ONLINE COMMENT ON PLANNING APPLICATION 24/10249

Location 1 PARKHILL CLOSE, HOLBURY, FAWLEY
SO45 2JE

Received Date 05 April 2024

Objection received from Mr Ralph Kent
5 Jonathan Close
Lymington
SO41 9DY
SO41 9DY

DRAWING TITLE: PROPOSED FLOOR LAYOUTS

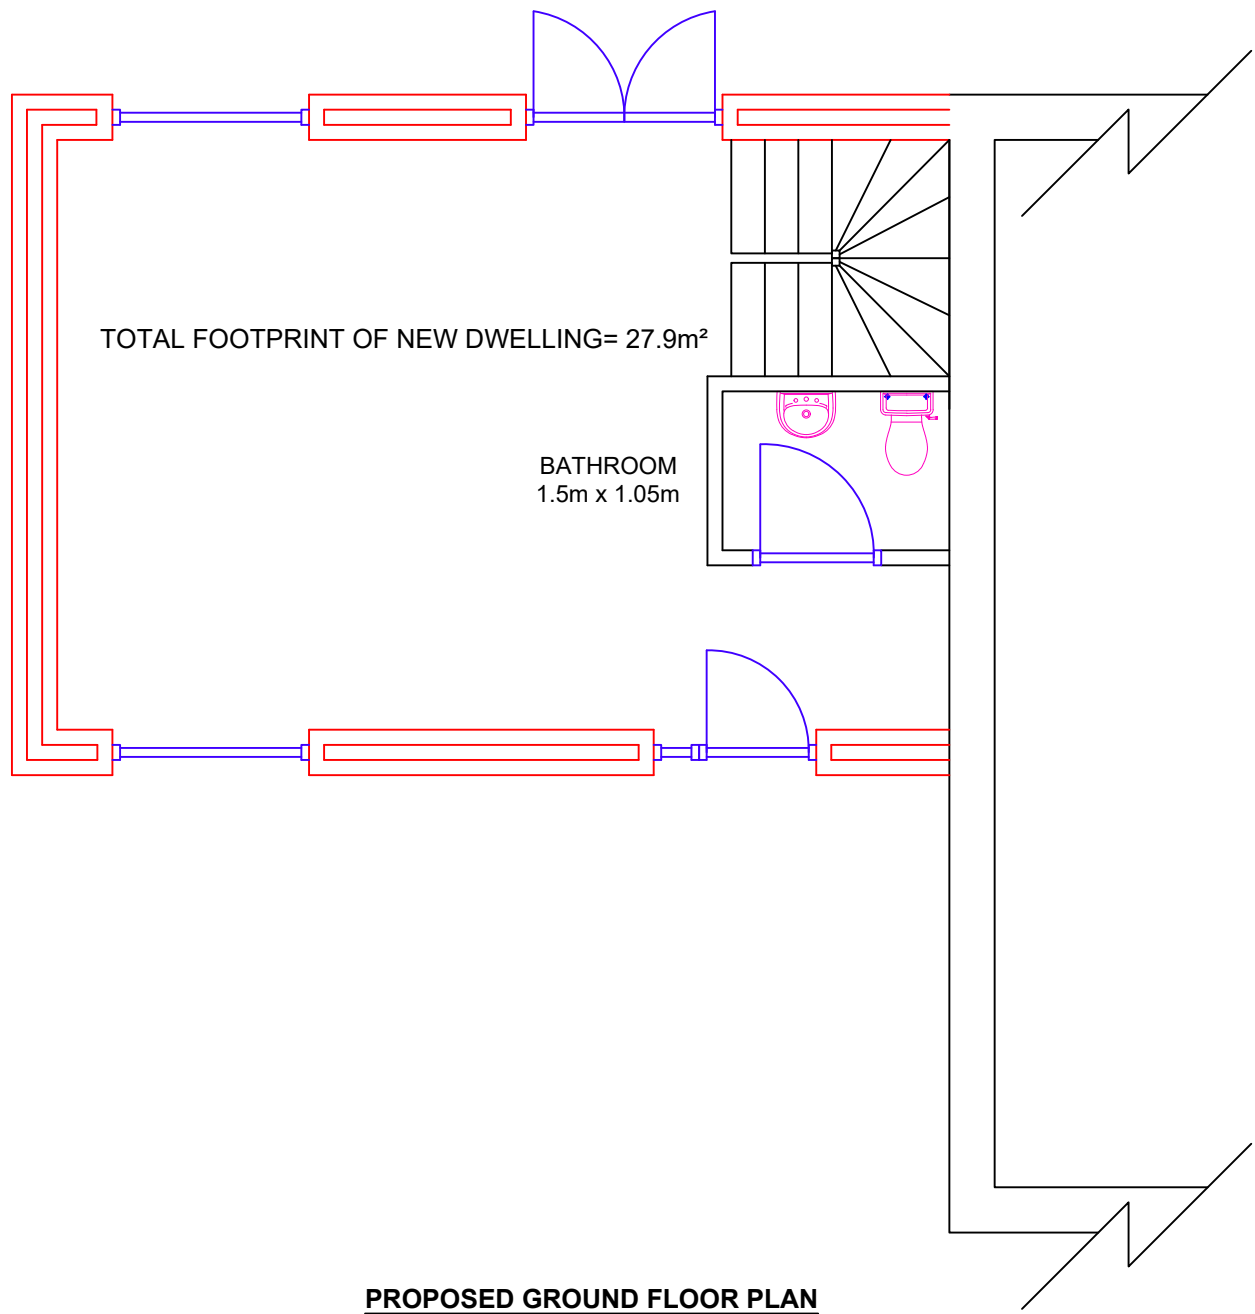
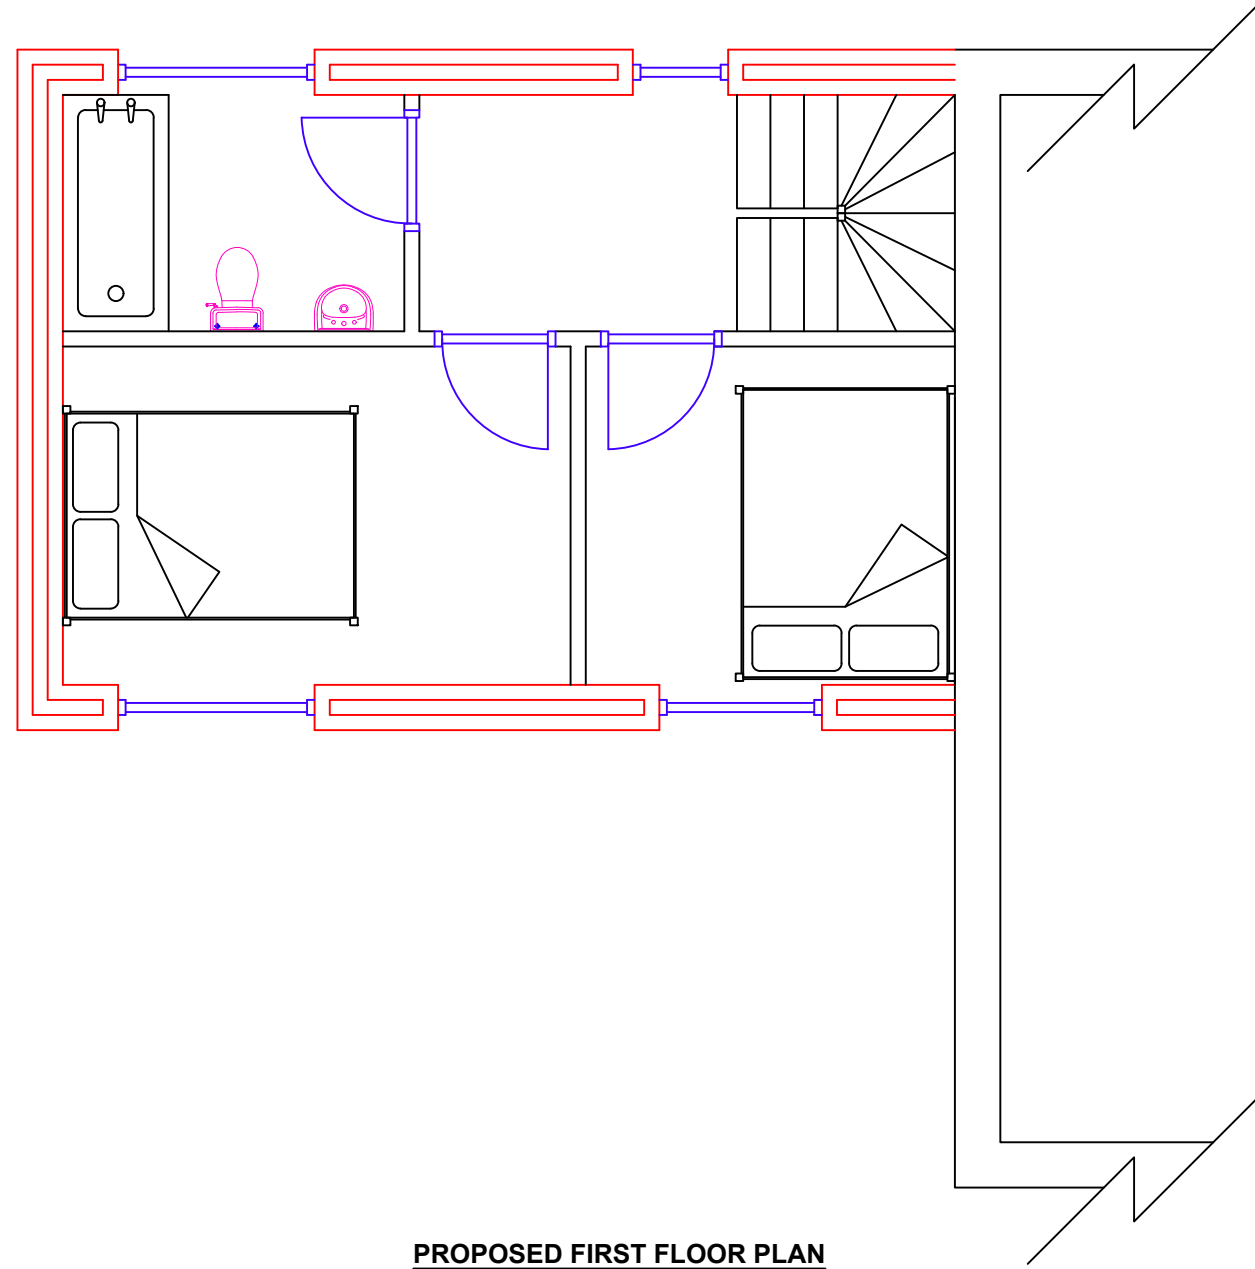
According to the space standards, a 2B3P 2-storey house should have a minimum GIA of 70m². According to the plans, the GIA of this proposed dwelling is just 46m².

According to the space standards, the main bedroom should be at least 2.75m wide and have a floor area of 11.5m². The larger bedroom on the plans has a floor area of just 7.6m² with a width of just 2.25m.

The smaller bedroom has an area of just 5.4m² (the minimum for a single bedroom according to the space standards is 7.5m²).

I also note that the floor plans do not include a scale bar or north arrow, so technically NFDC should not have validated the application.
